Addendum No. 1

RE: Contract # C203818

Cumberland, Harnett Counties (I-5788)

I-95 From North Of NC-24 (MP-53) To Johnston County Line (MP-78)

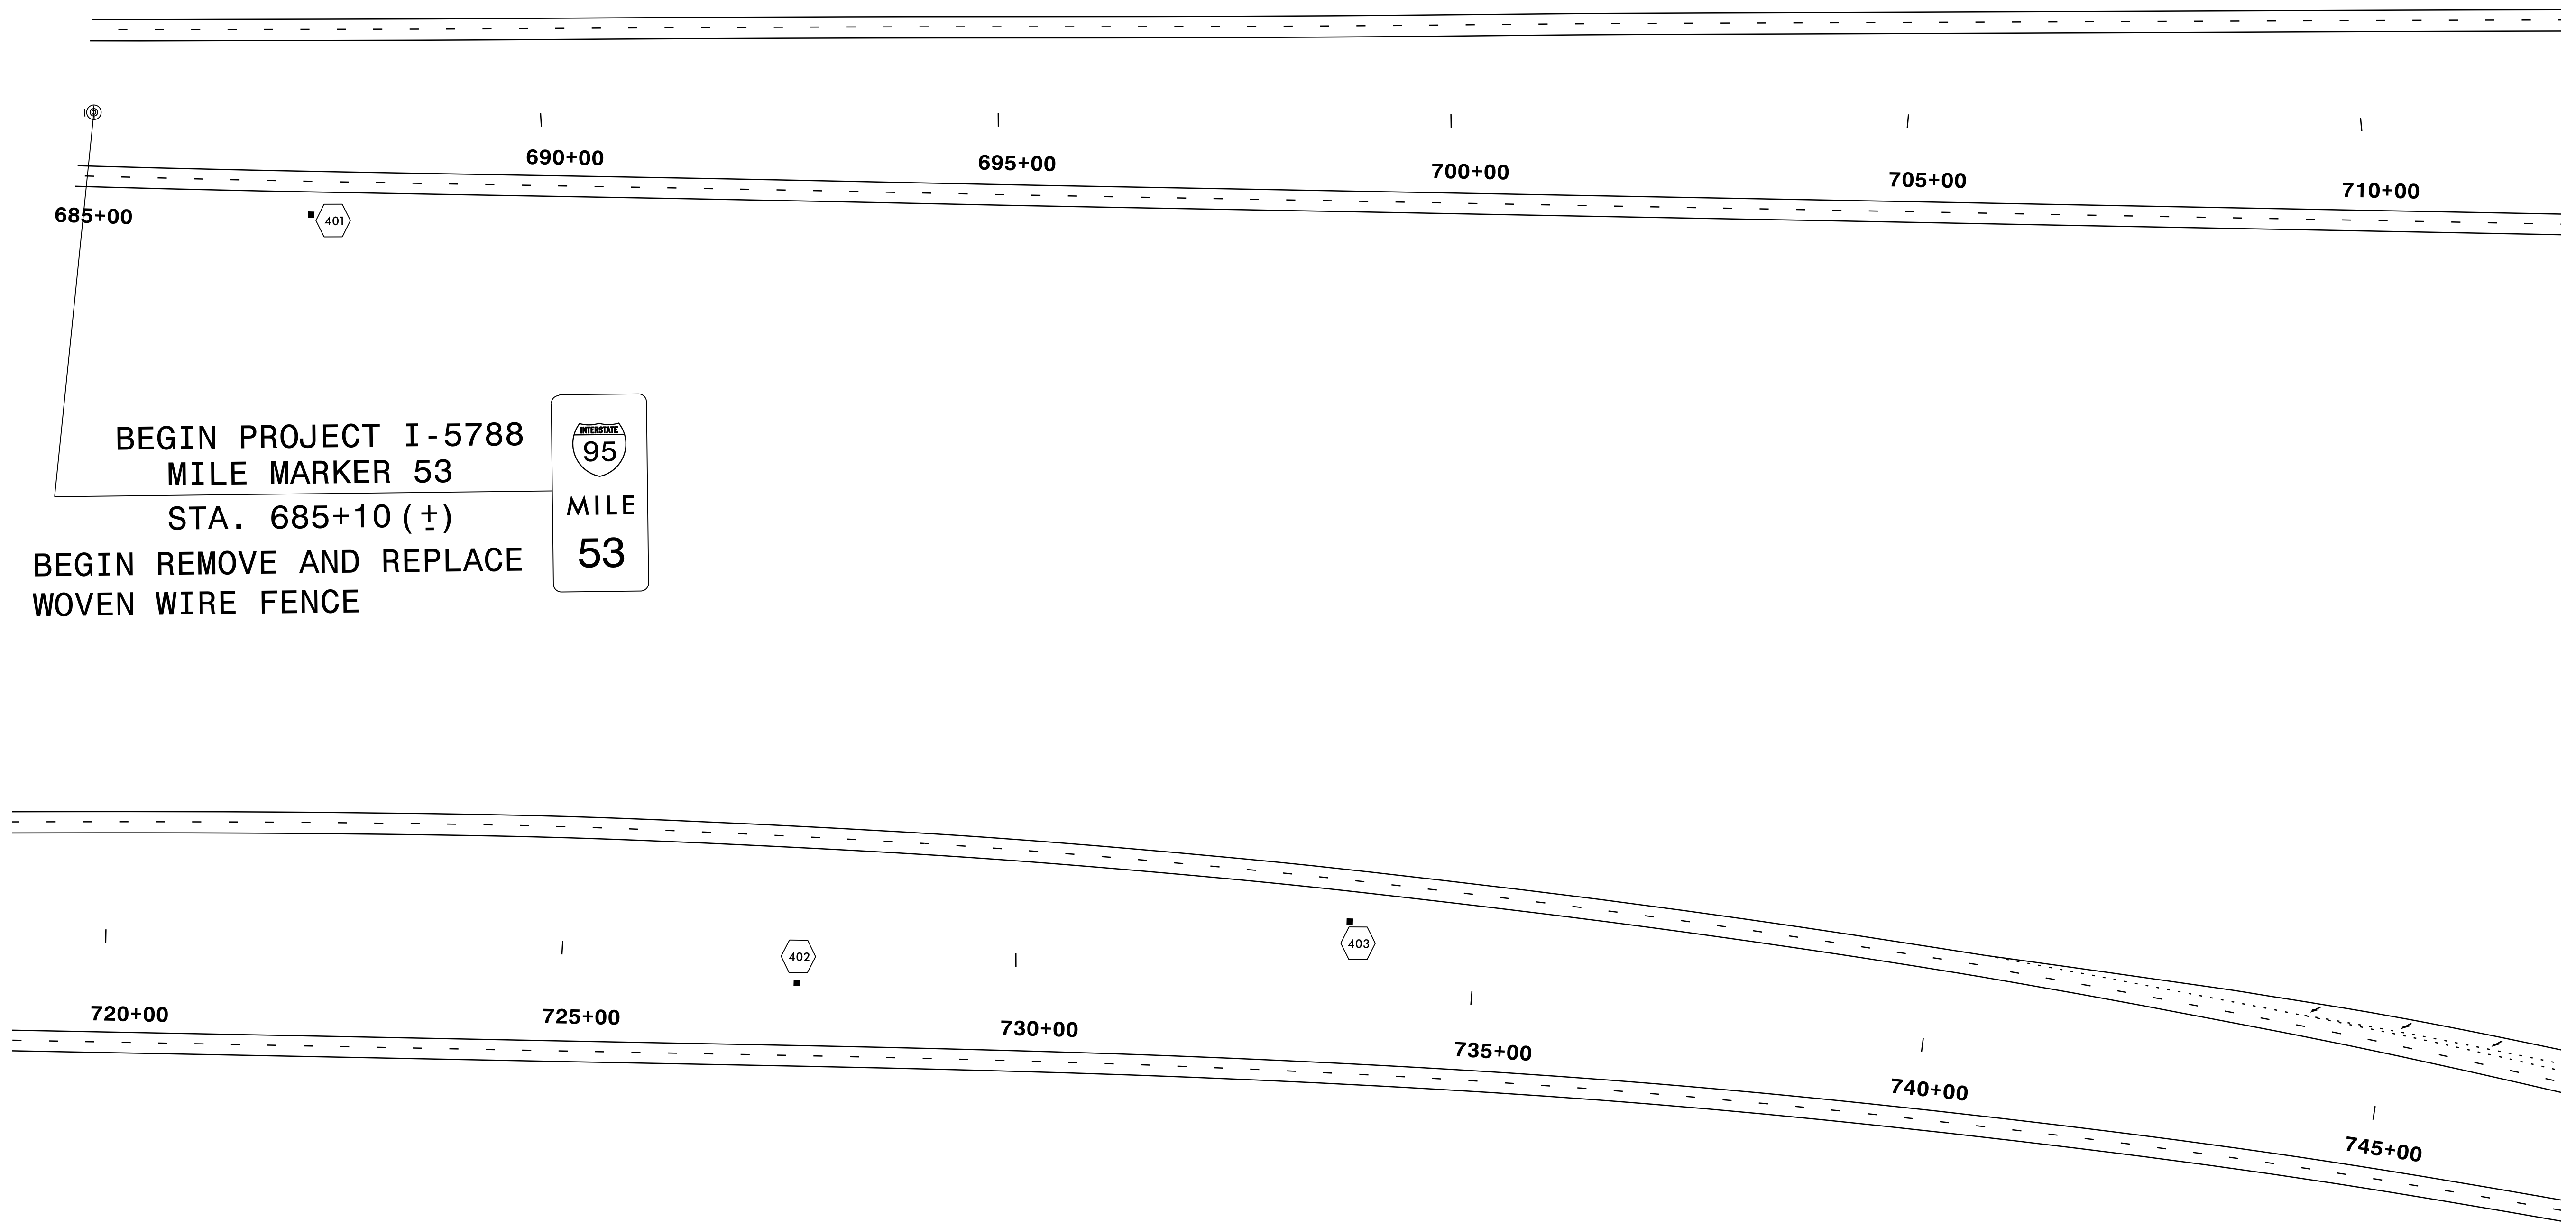
Sheet No. 3B-2 has been revised to reflect the below noted pay item description change. Please void Sheet No. 3B-2 in your plans and staple the revised Sheet No. 3B-2 thereto.

<u>Item</u>	<u>Description</u>	<u>Old Quantity</u>	<u>New Quantity</u>
008-1575000000-E-620	Asphalt Binder For Plant Mix	8,494 TON	DELETED
008-1577000000-E-620	Polymer Modified Asphalt Binder For Plant Mix	NEW ITEM	8,494 TON
